# CITY OF ALBUQUERQUE

May 29, 2015

**RE: Dreamstyle Warehouse, 1525 Renaissance Center  
Grading and Drainage Plan  
Engineer's Stamp Date 5-04-2015 (File: F16-D051A)**

Based upon the information provided in your submittal received 5-05-15, the above referenced Grading and Drainage Plan cannot be approved for Building Permit until the following comments are addressed:

TRACT 9A	DRAWN BY BJF
	RENAISSANCE CENTER	DATE 05/04/15
	GRADING AND DRAINAGE PLAN	2015009-GRB
	TERRA WEST, LLC 5571 MIDWAY PARK PLACE NE ALBUQUERQUE, NM 87109 (505) 858-3100 www.tierrawestllc.com	SHEET # D2 JOB # 2015009

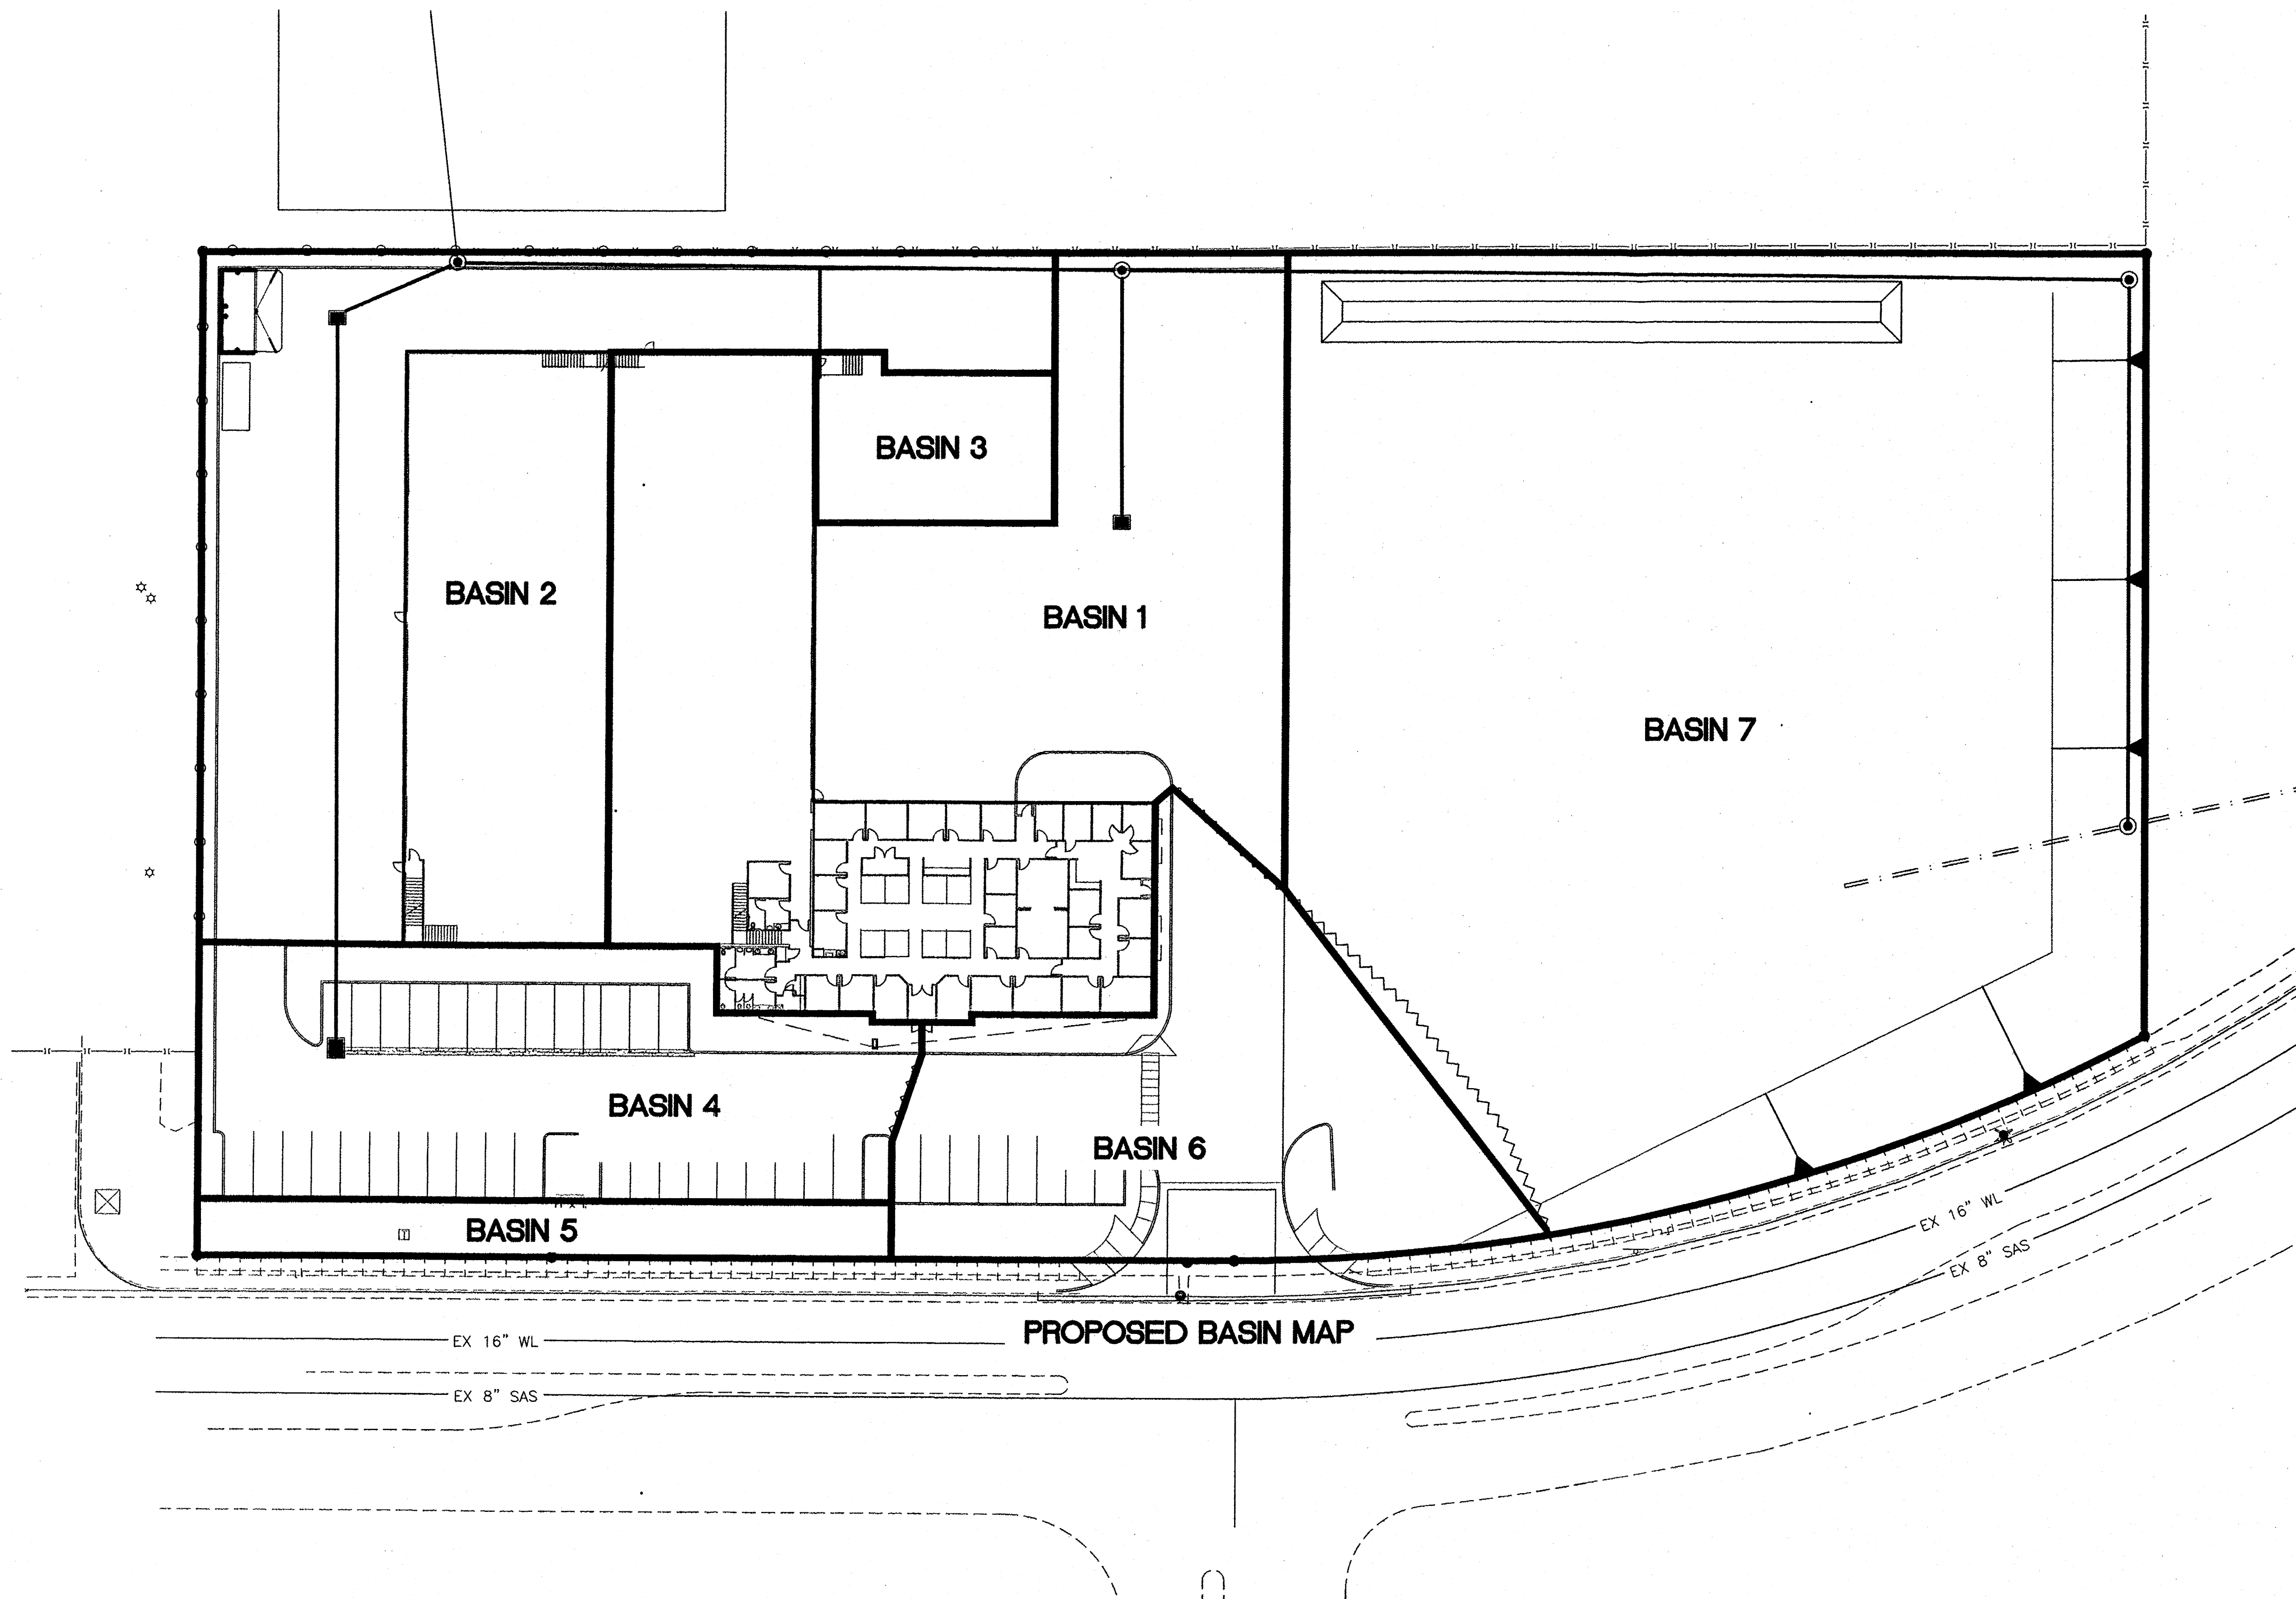
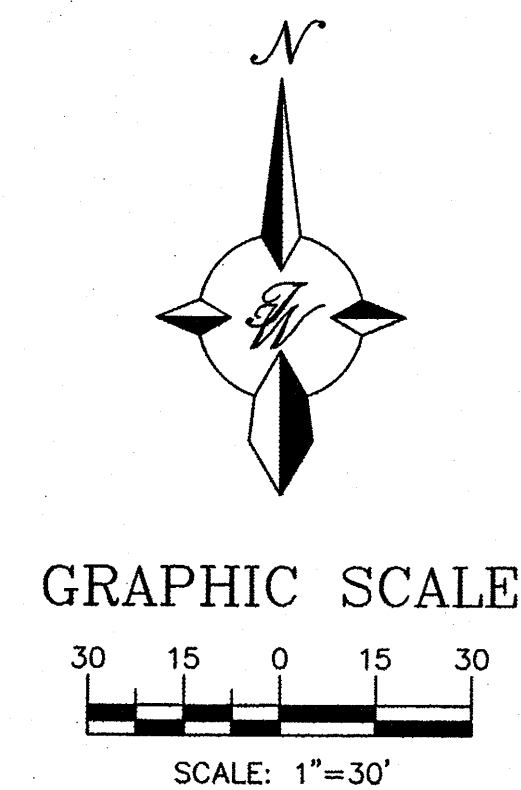
- 1) The First Flush Pond area must retain the impervious area of the currently proposed building at a depth of 0.34" and not be intended to only allow drainage from future impervious development on Basin 7. Show drainage from new building construction to a first flush pond area instead of directly draining it into the new storm drain system. Based on the site plan layout, some options may be to provide an area within small pervious area at the southwest corner of the building while maintaining the required minimum distance away from the building, providing a roof drain to directly tie into the currently proposed first flush pond location, and utilizing the pervious area south of the proposed parking lot. Show all roof drains for new building.

- 2) Label existing contours, particularly the major ones. Also provide new contours for the site along the 3:1 slopes.
- 3) Show existing and new contour elevations around the perimeter of the site to show how new grading ties into existing and does not adversely impact adjacent sites. Also include existing spot elevations along Renaissance Blvd, and label Renaissance Blvd. on the plan view.

- 4) Reference that the 9.79 cfs of off-site flow came from the Master Drainage Plan. In addition to the 9.79 cfs entering the site from the storm drain, address how much off-site flow is coming from the sloped area to the east of the site and show this off-

site basin area in the calculations. Call out existing pipe size that is conveying the 9.79 cfs. With this addition, maintain an overall site discharge of below 24.97 cfs to Pond 5.

5) For the entryway into the site, call out COA Standard Dwgs. 2426 and 2420 as applicable.

6) For connection of dock drain into the main storm drain, call out a tee connection and invert elevation.

7) Correct spot elevation showing "50730.0" at the corner of the building to correct elevation.

8) If 0.66 cfs is allowed to be discharged into the street, the allowable flow should be met unless it can be shown that the street and the downstream storm drain system in Renaissance that will be capturing this flow can handle the additional 0.96 cfs.

9) Show capacity calculations for on-site inlets.
